Narrabri Gas Project - Aboriginal Cultural Heritage Assessment

Submission Response - Gomeroi Traditional Custodians- Elders and community RAPs

20 May 2017

The Aboriginal cultural heritage zoning scheme is illustrated in the sensitivity mapping in Figure 20-2.

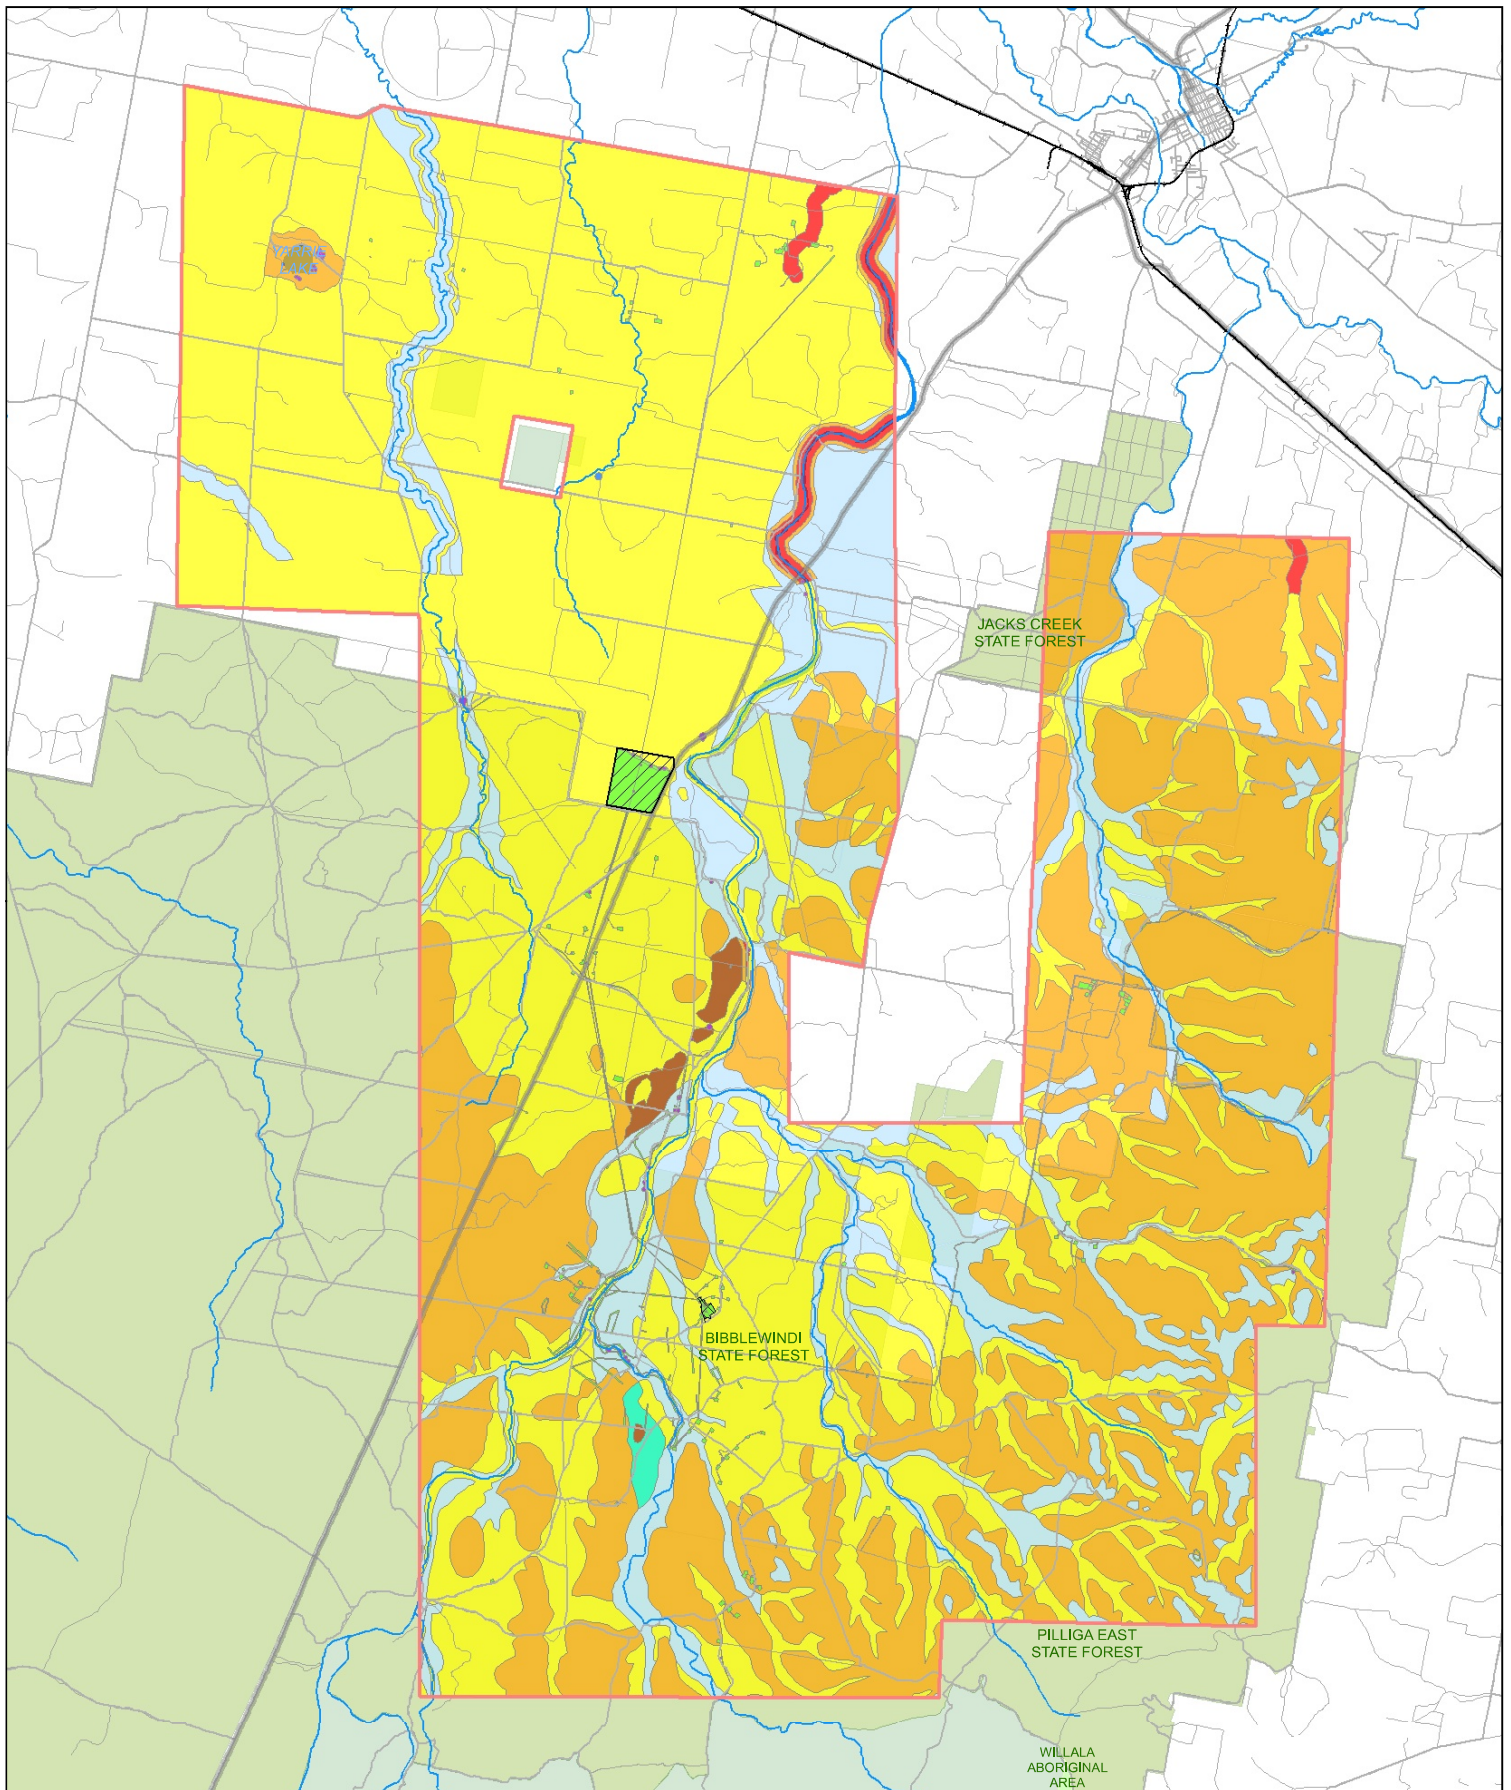
We hold grave concerns that it appears to be a table the ACHA and an approval will take care of the rest! This approach is inconsistent with archaeological practices and State significant considerations as defined by the EIS assessment requirements.

The review by Kuskie which we attach also finds that this mapping is fundamentally flawed because it relies on very limited data and has failed to include important elements like geology, gradient and vegetation.

The approach to have a 'claytons' predictive modelling and 'cultural sensitivity mapping' post approval is fundamentally flawed and cannot be supported by the Gomeri Traditional Custodians and our Elders.

As continually stated during the assessment the cultural heritage zone scheme appears to be some half baked methodology based on the notion of understanding surface archaeological evidence not based on an informed knowledge of the cultural landscape and its uses and significance over time for Aboriginal people especially the Gomeroi.

Our concerns are also identified by Kuskie's expert review, the cultural heritage assessment report launches into a "Cultural Heritage Zone Scheme" for a vast area with no development of a model of Aboriginal occupation and use of the landscape, inadequate consideration of the environment of the Project area and inadequate definition of the expected nature and distribution of Aboriginal heritage evidence.

- We the Gomeroi Traditional Custodians and RAP members can't even on the basis of the information provided, have any rhyme or reason of the selection of Zones and the information and cultural values of RAPs to inform such modelling and zone planning.
